Engineering Report: Assessment of Glint, Glare and Visual Impact from Proposed Green Hill Solar Farm (Green Hill G)

From: Mark Shepherd CEng/PrEng

Date: 19 October 2025

Subject: Preliminary Opinion Assessment of Glint, Glare and Visual Impact from Proposed Green Hill Solar Farm (Green Hill G)

Title: Figure 8.7.5 Visual Receptors
Green Hill G

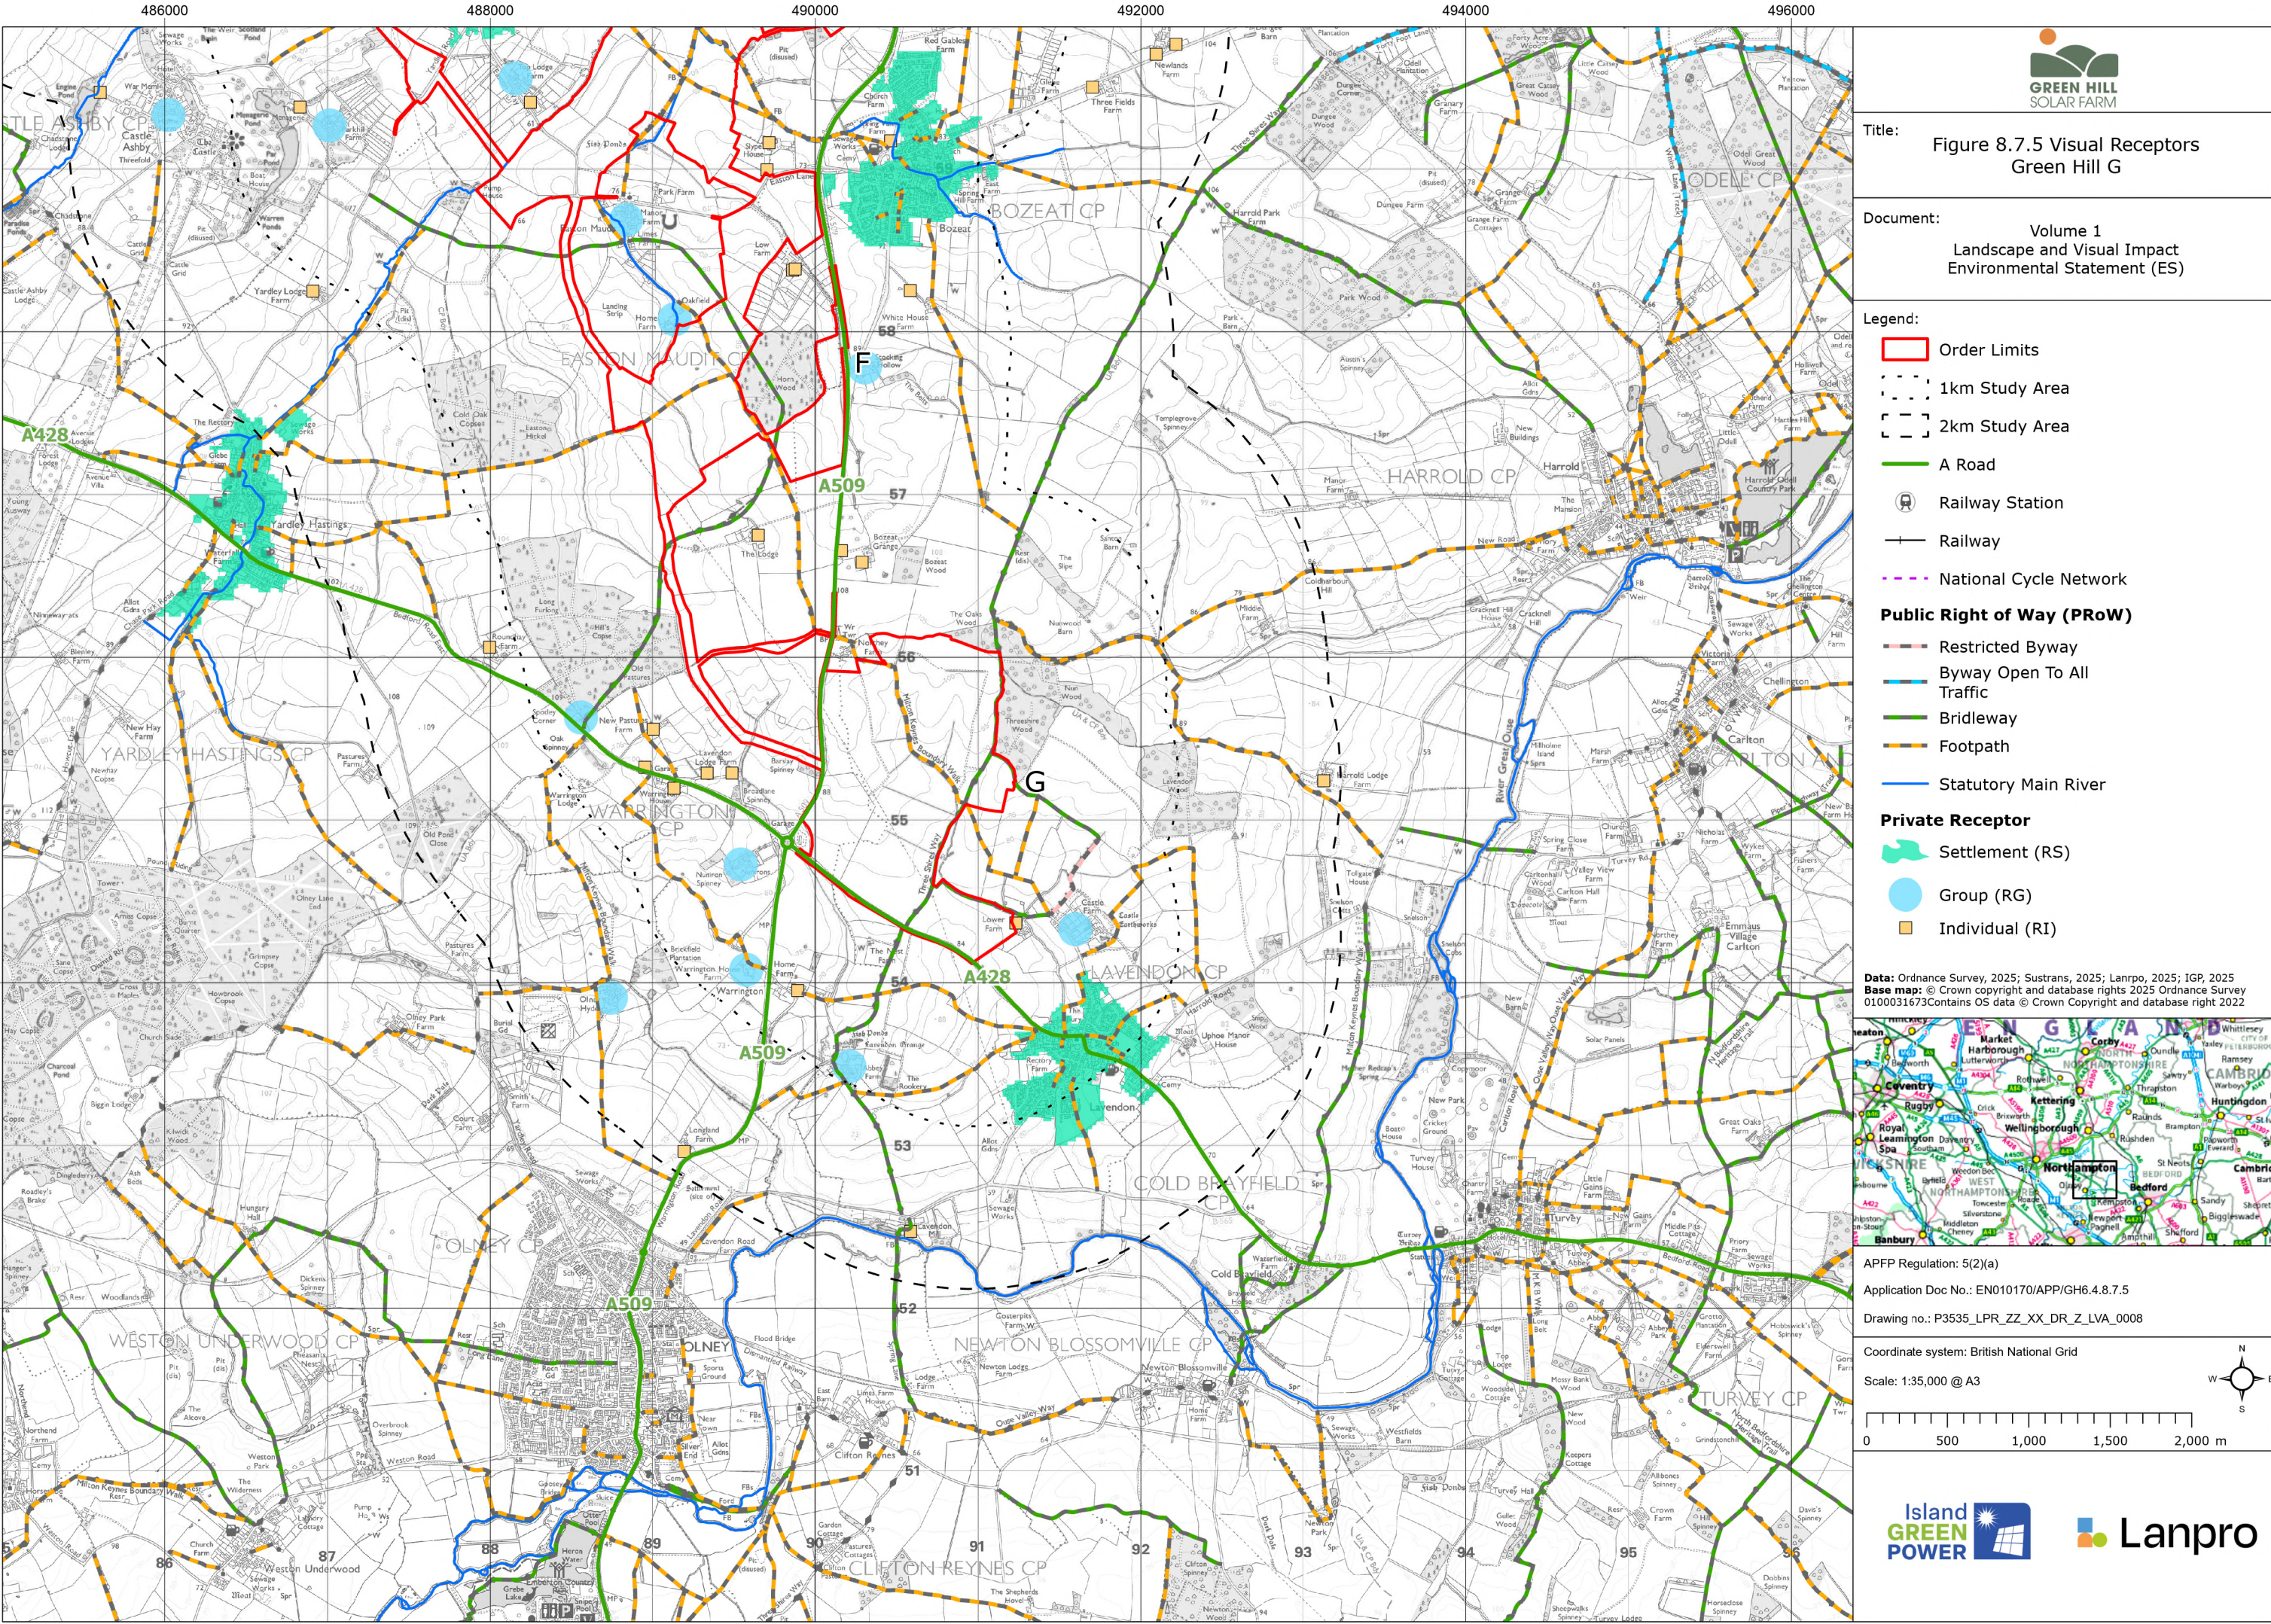
The Developer's reports on Glint and Glare, Visual Receptors Green Hill G and Landscape and Visual Impact Assessment provide misleading evidence and have omitted significant assessments that are relevant to the assessment of the proposed development.

What is concerning is that all the visual receptor points have been taken from the edges of the development, pointing inwards, which doesn't actually represent reality and provides a very misleading documentation of visual impact.

Title: Figure 8.10.5 Viewpoint Locations
Green Hill G

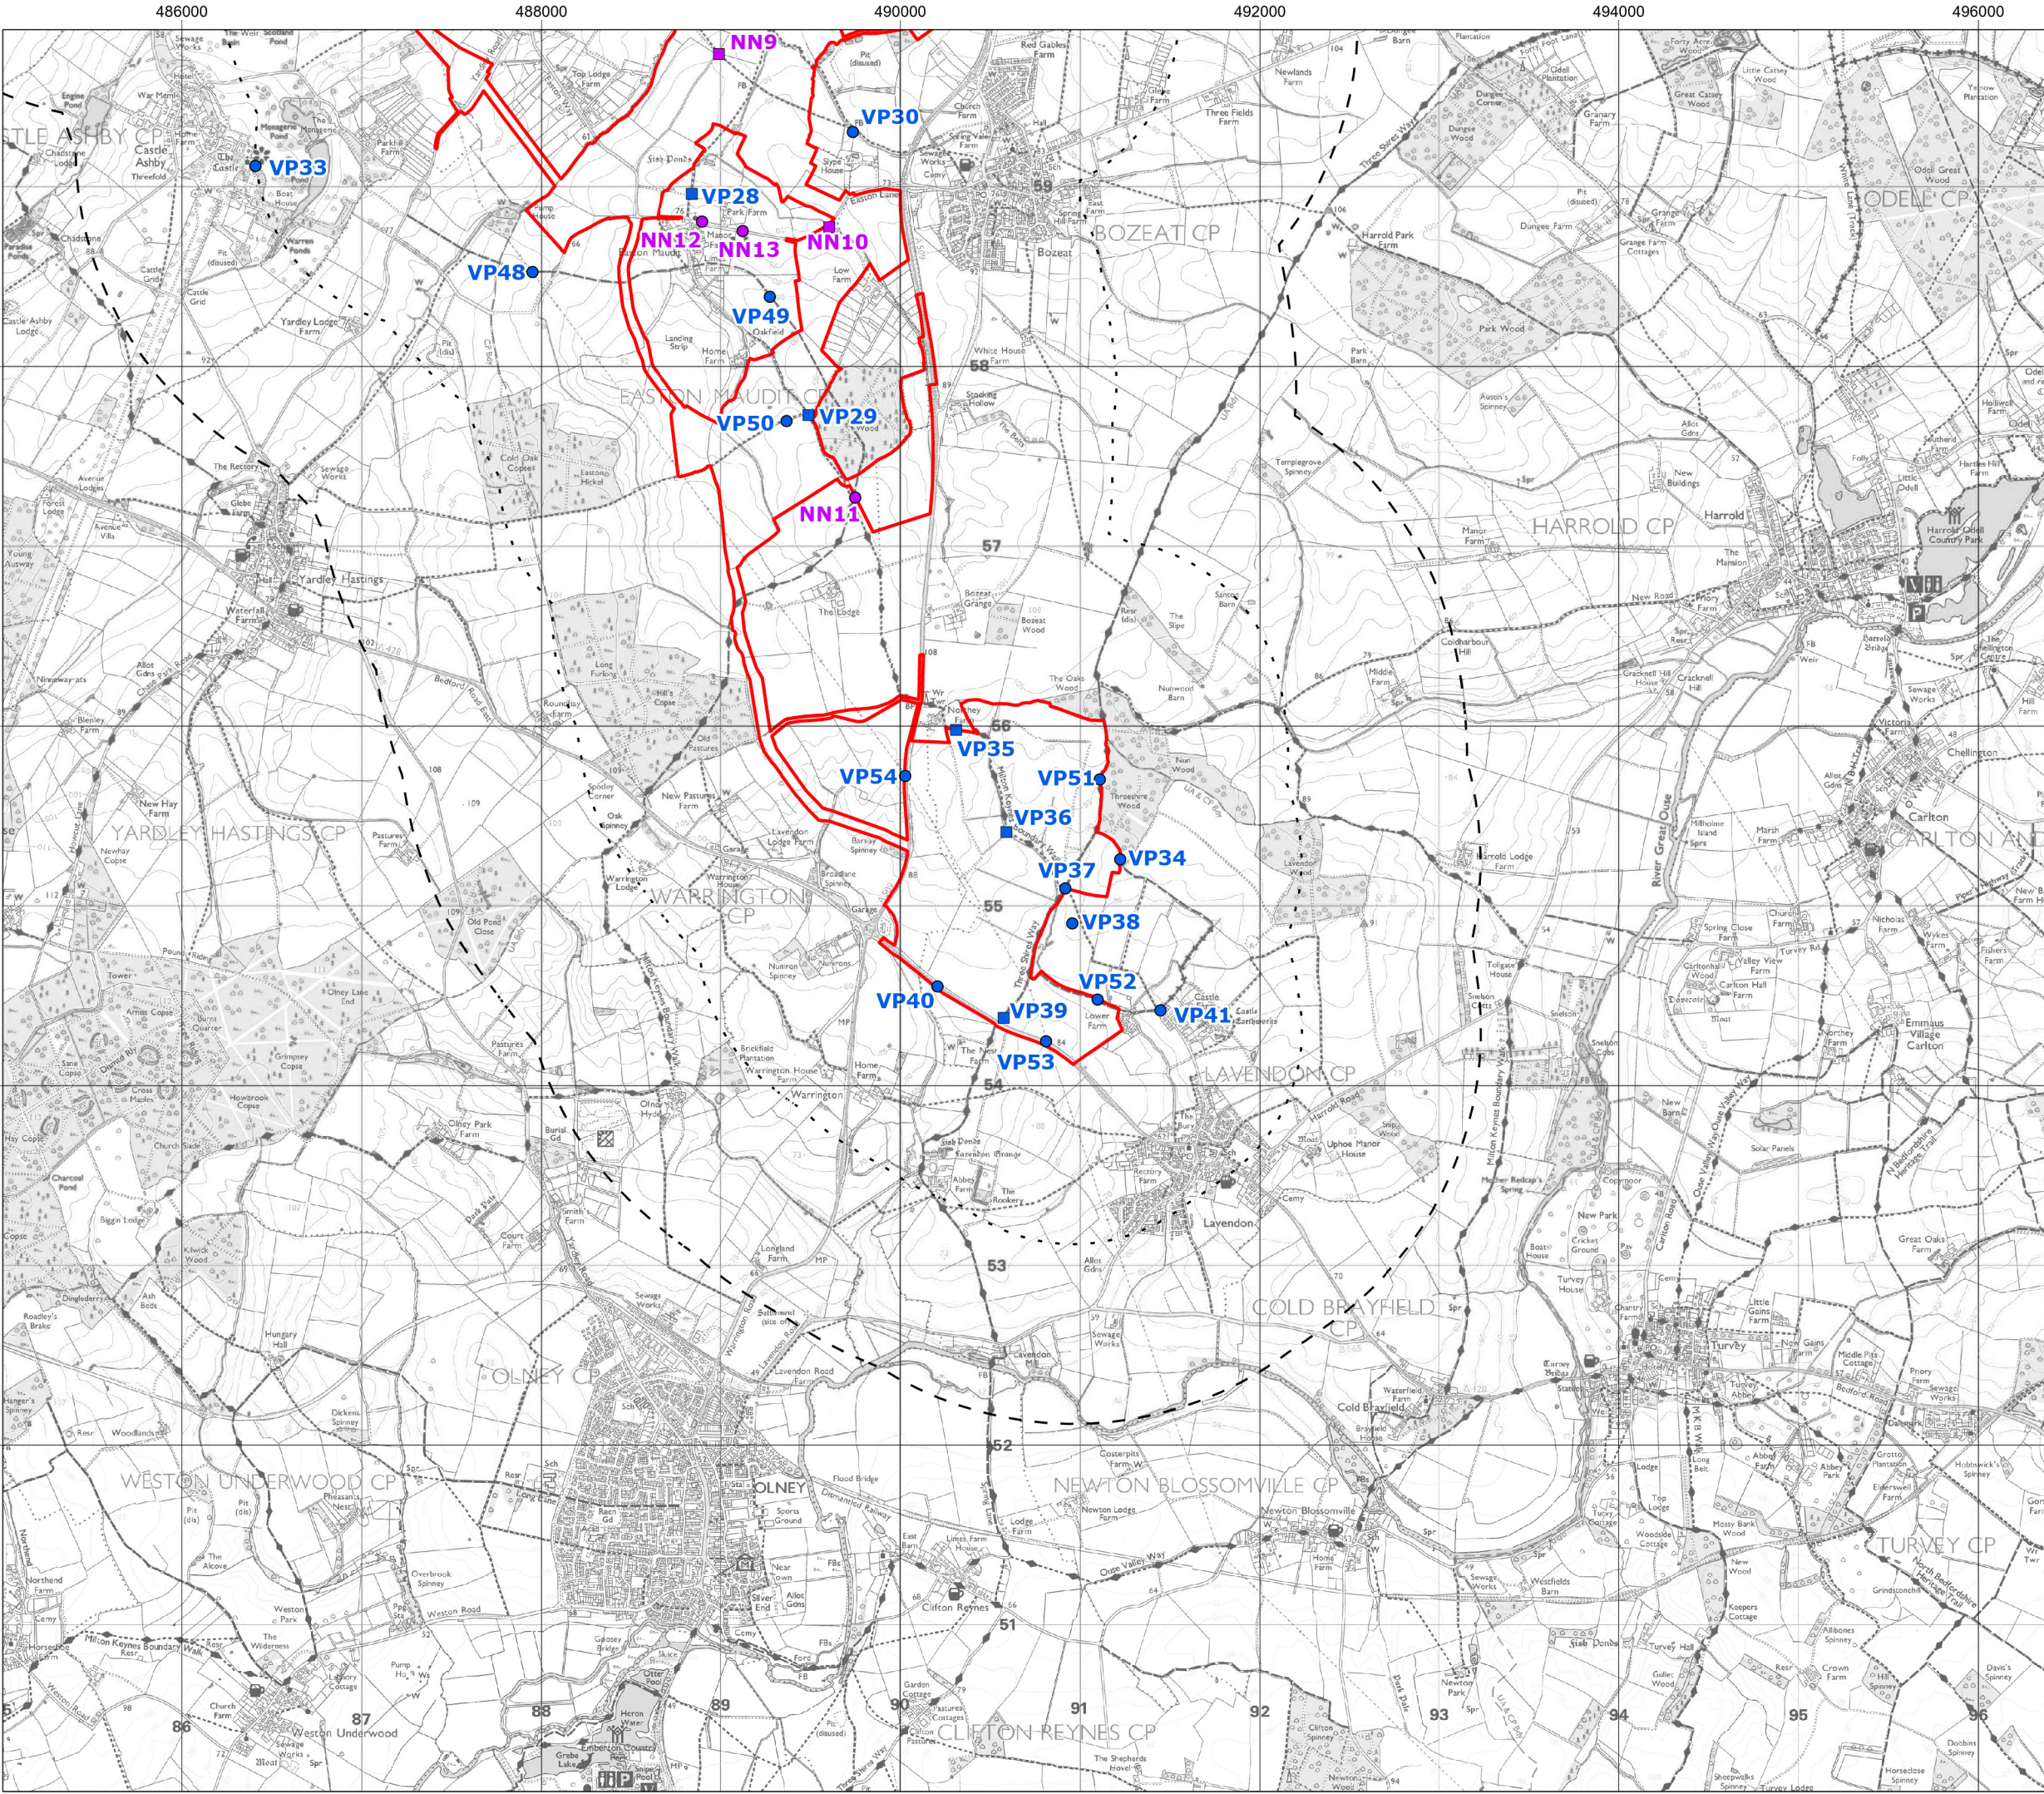
A summary of the viewpoints used for Green Hill Site G have been shown below. What is entirely misleading is that the viewing points have been taken from the boundaries of the development only, not from the perspective of the village.

From VP40, the following images were provided (2/3 of a 360° view pointing inwards to the development):

From VP41, the following image was provided (2/3 of a 360° view pointing inwards to the development). Only one spliced photo has been included, completely misrepresents the actual situation, and totally ignores a viewpoint that includes Three Shires Way:
